re: **Geotechnical Response to Engineering Review Comments**  
**Proposed Multi-Storey Building**  
**61 Pinehurst Avenue – Ottawa, Ontario**

date: February 9, 2022

file: PG5720-MEMO.01

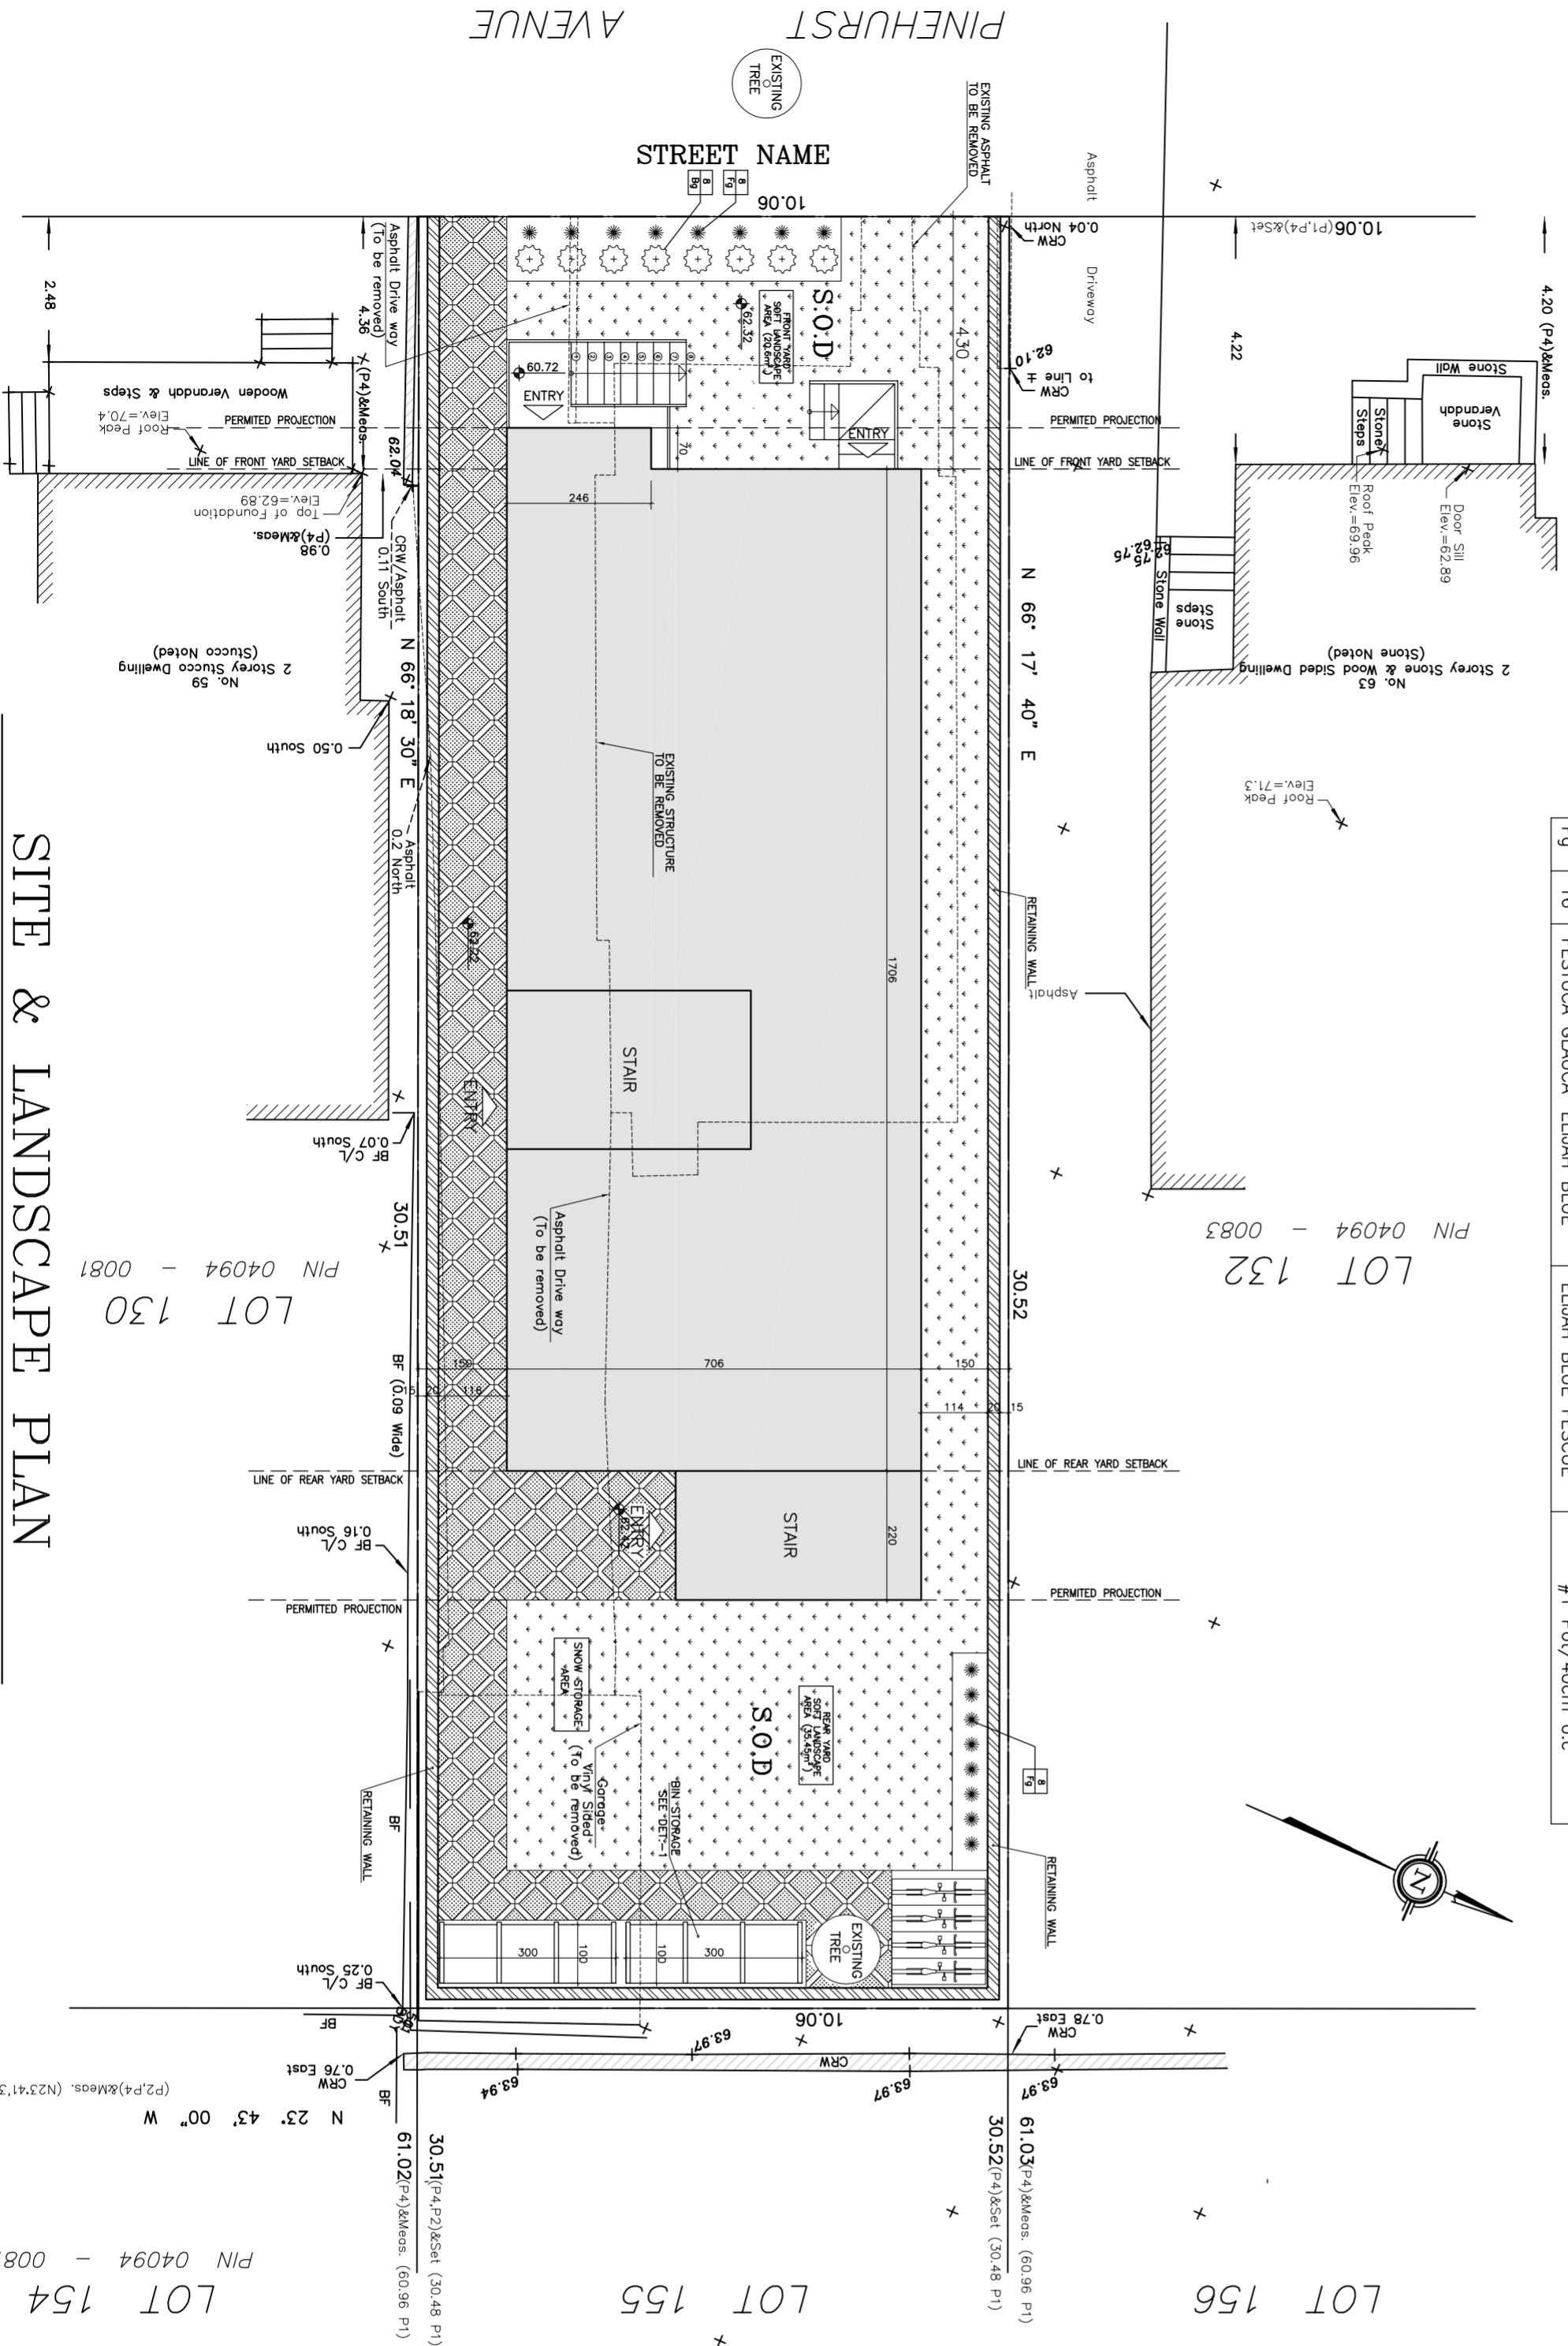
**Comment 44:** *Please provide a revised report or confirmation that the design drawings have been received and reviewed.*

**Response:** Paterson reviewed the following design drawings prepared by Republic Urbanism for the proposed development:

- ☐ Site & Landscape Plan – 61 Pinehurst Ave., Ottawa – Project No. 2021-001 – Drawing No. SP&LP101 – Revision 2 – Dated October 9, 2021
- ☐ 61 Pinehurst Ave., Ottawa – Project No. 2021-001 – Drawings No. A06 to A09 – Revision 2 – Dated October 9, 2021

Due to the absence of a silty clay deposit at the subject site, permissible grade raise restrictions were not required for the subject site, from a geotechnical perspective. Furthermore, due to the absence of a silty clay deposit at the subject site, tree planting restrictions are not applicable for the proposed development. Therefore, based on our review of the above-noted drawings, and in consideration of the subsurface profile encountered at the time of our investigation, the design drawings are considered acceptable from a geotechnical perspective.
